**KIRKLEES METROPOLITAN COUNCIL
INVESTMENT & REGENERATION SERVICE**

DELEGATED DECISION TO DETERMINE PLANNING APPLICATIONS

Reference No:	2025/62/90786/E
Site Address:	89, Providence Court, Thornhill Lees, Dewsbury, WF12 9HX
Description:	Erection of detached garage and installation of first floor window
Recommending Officer:	Jennifer Booth

DECISION - REFUSED

PROPOSED ELEVATION OF GARAGE IN H.No. 89 PARKING SPACE.

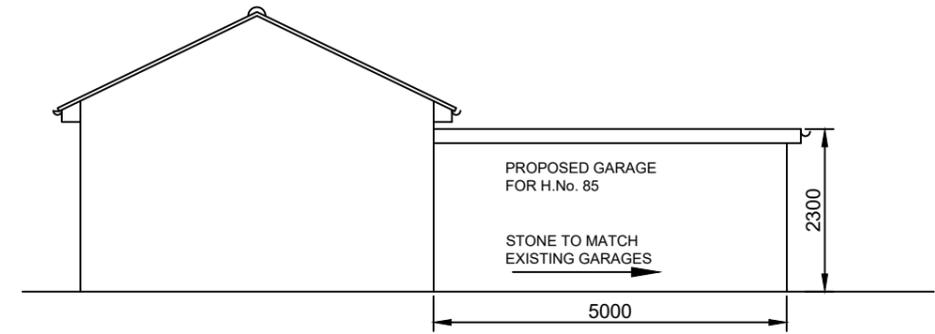
The garage, would appear at odds with the existing grain of development given that no other garages are present in this particular location in what was originally designed as an open courtyard parking area. The existing garages to the rear were planned as part of the original development scheme and are set in linear format to the rear of the site, consistent with the grain and design of built form.

Whilst the detached garage would be modest in scale and constructed of materials that are in keeping with those in the vicinity it would be a flat roofed outbuilding isolated from the dwelling and in a currently open area resulting in ad hoc development in a planned estate. In erecting a single garage in the location proposed it would appear incongruous within the space to the detriment of the area and original layout of the development. Whilst each proposal should be assessed on its own merit the erection of one garage could result in other sporadic development that would not be in the interest of visual amenity.

Having taken the above into account, whilst the change to the window would be acceptable, the proposed garage would result in significant harm to the visual amenity and character of the area. As such, the development would conflict with Policy LP24 of the Kirklees Local Plan—specifically part (a), due to concerns with the form, scale and layout, and part (c), as the extension would not appear as a subservient addition in keeping with the existing building and the objectives of chapter 12 of the National Planning Policy Framework.

The proposed garage would reduce the amount of designated off-street parking available to the property. Although its scale and appearance may be comparable to other garages within the wider site, the internal dimensions of the structure fail to meet current minimum standards for usable parking spaces, raising concerns about its practicality and functionality. Erecting a building in the position shown would interfere with manoeuvrability to the adjoining parking spaces as well as significantly decreasing accessibility for users of those spaces. The development would, therefore, result in the loss of useable parking spaces associated with the dwellings and displacement of those vehicles.

PROPOSED BLOCK PLAN (SCALE: 1/200)

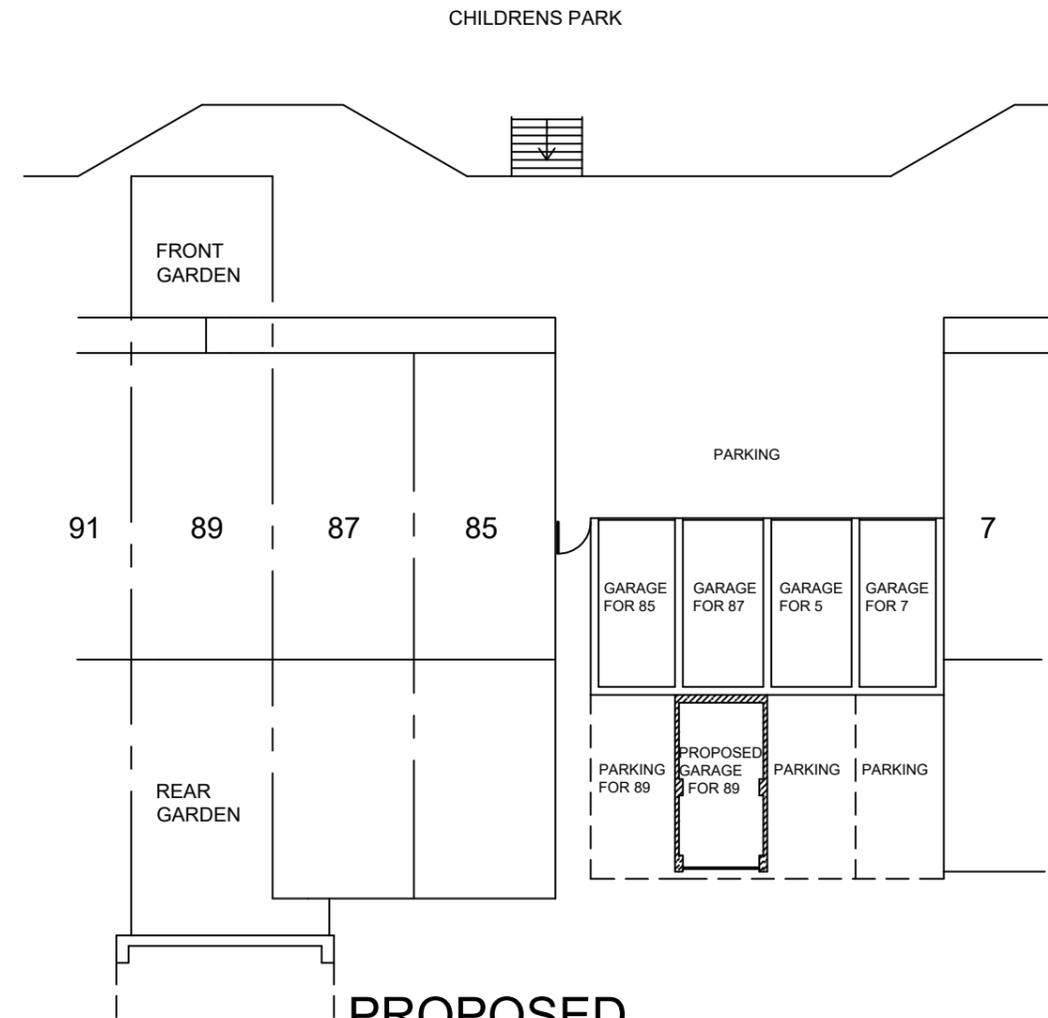
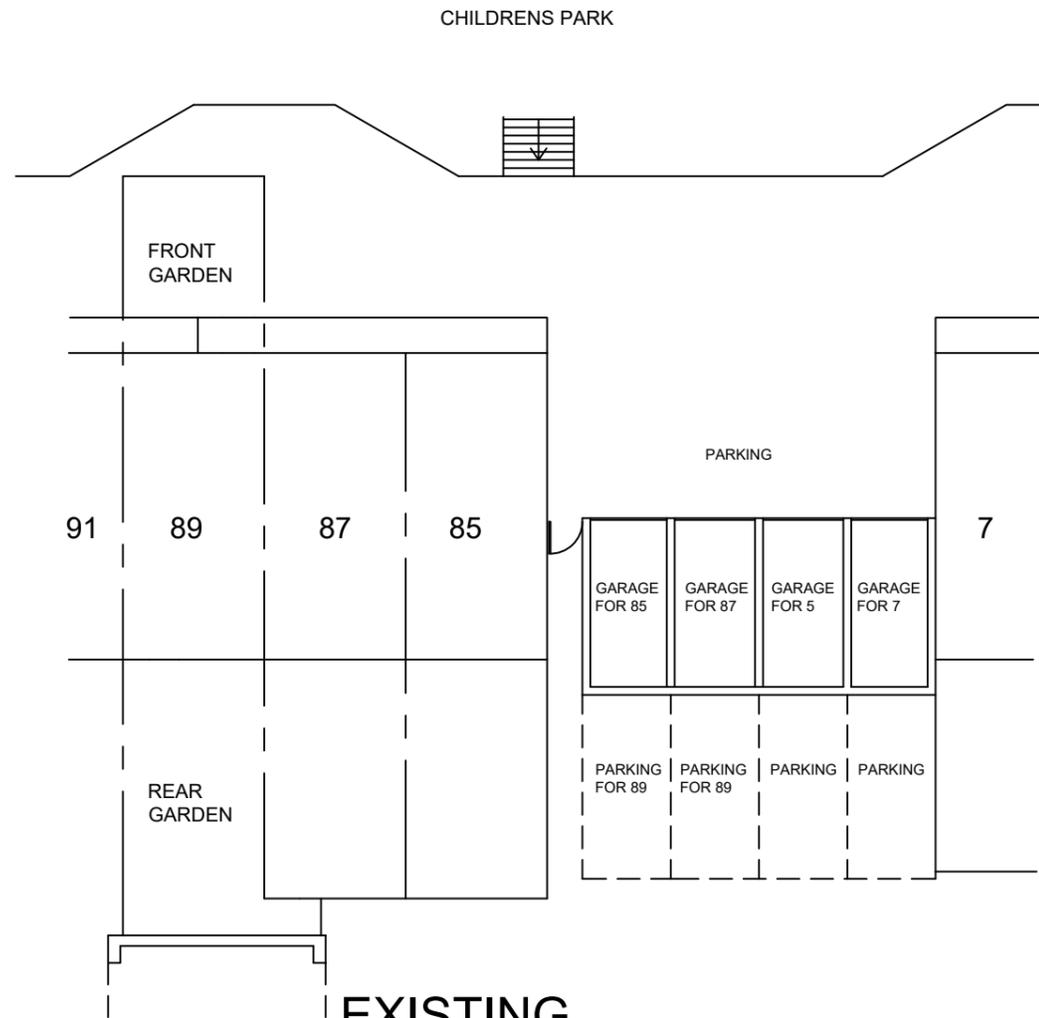
The three bedroom property would be left with only one off-street parking space, and while some on-street parking exists in the vicinity, reliance on this is not considered appropriate. Site observations indicate on-street parking is already utilised in the area, introducing further dependence on it could lead to future issues of demand and congestion or obstruction around residential properties to the detriment of pedestrian and highway safety.

The erection of a structure in an open car park will reduce natural surveillance of the parking area increasing the risk of crime contrary to Policy LP24 e.

**PROPOSED GROUND FLOOR PLAN SHOWING
 PROPOSED GARAGE IN PARKING SPACE AND
 FRONT FIRST FLOOR WINDOW AMENDED.**

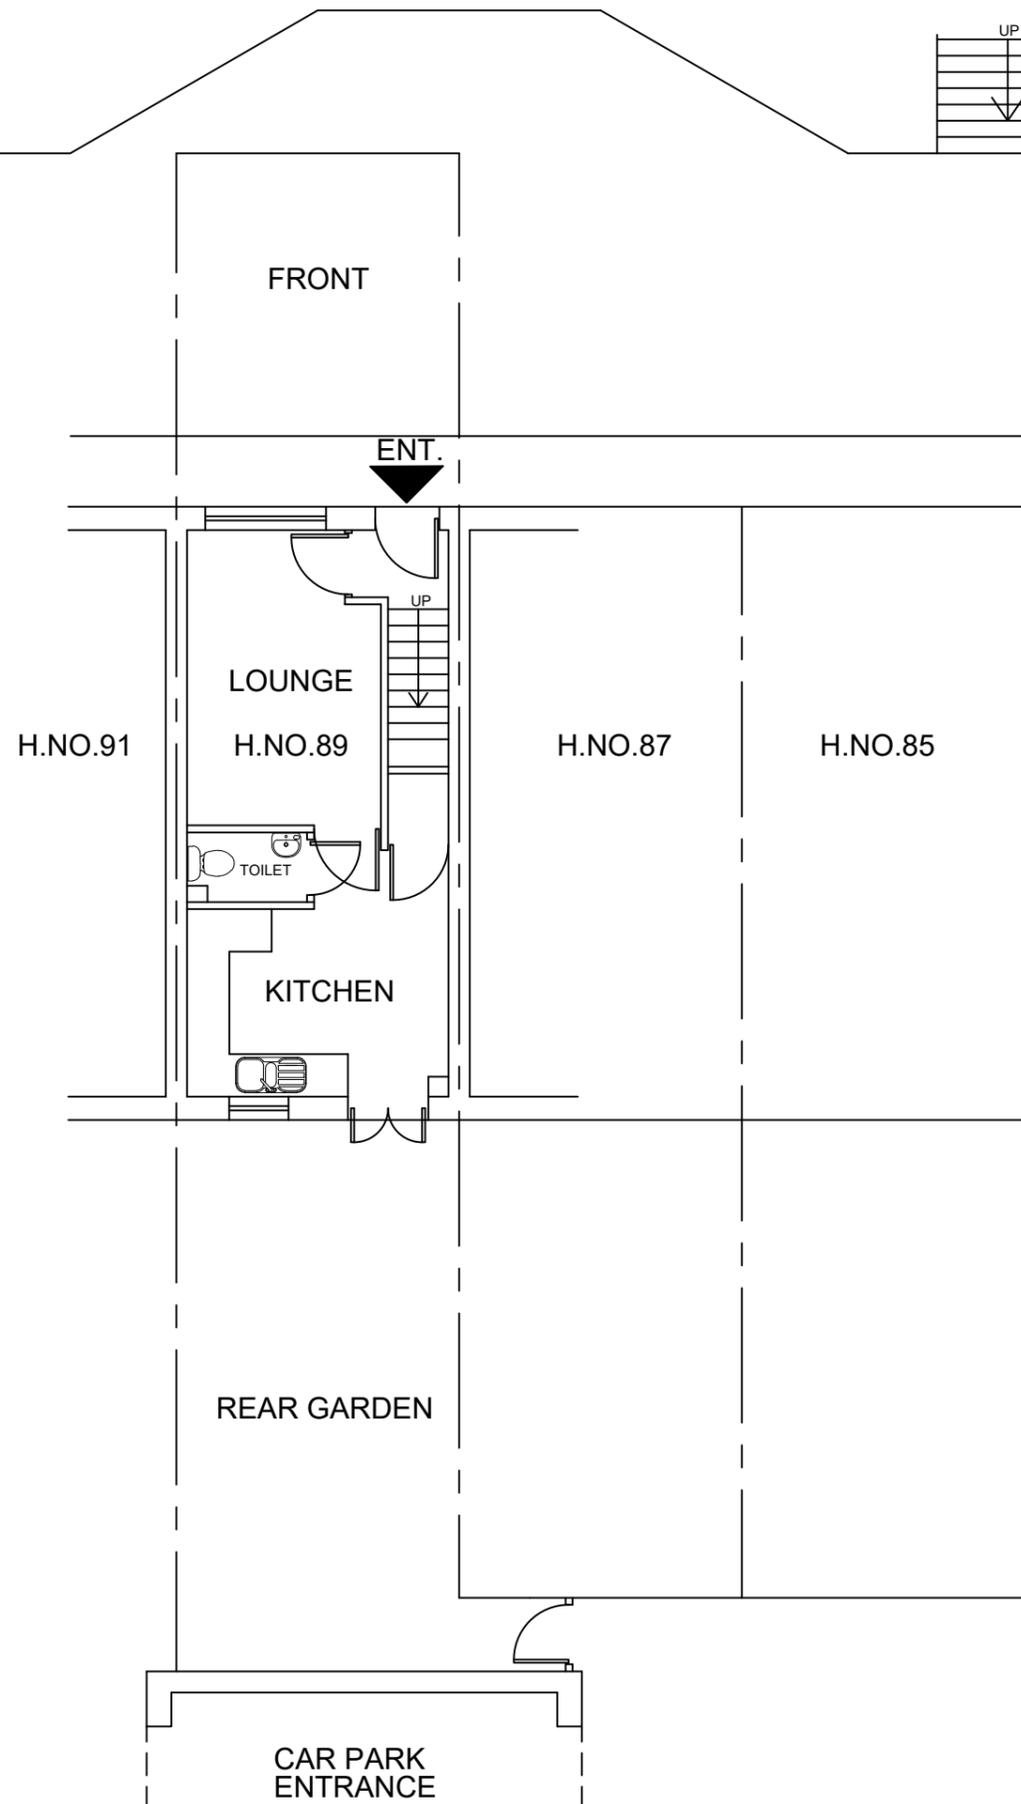
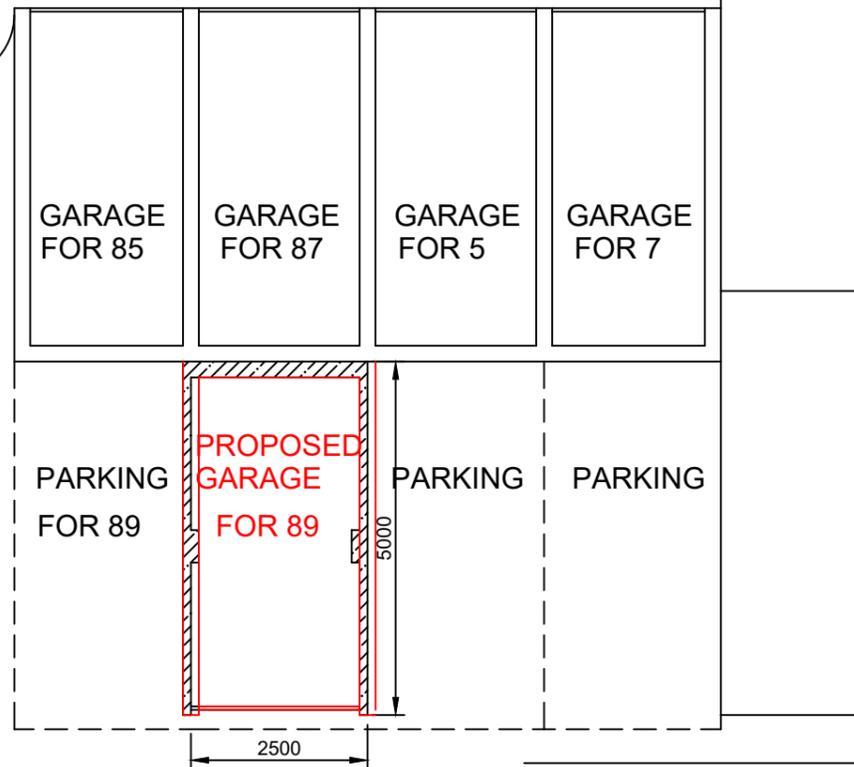
The proposed fenestration alterations are minor and would not significantly alter the character or appearance of the host dwelling. The bottom of the window line would be dropped and would align with the level of the window on the adjoining dwelling.

The fenestration changes face onto public open space and do not introduce any additional opportunities for overlooking.
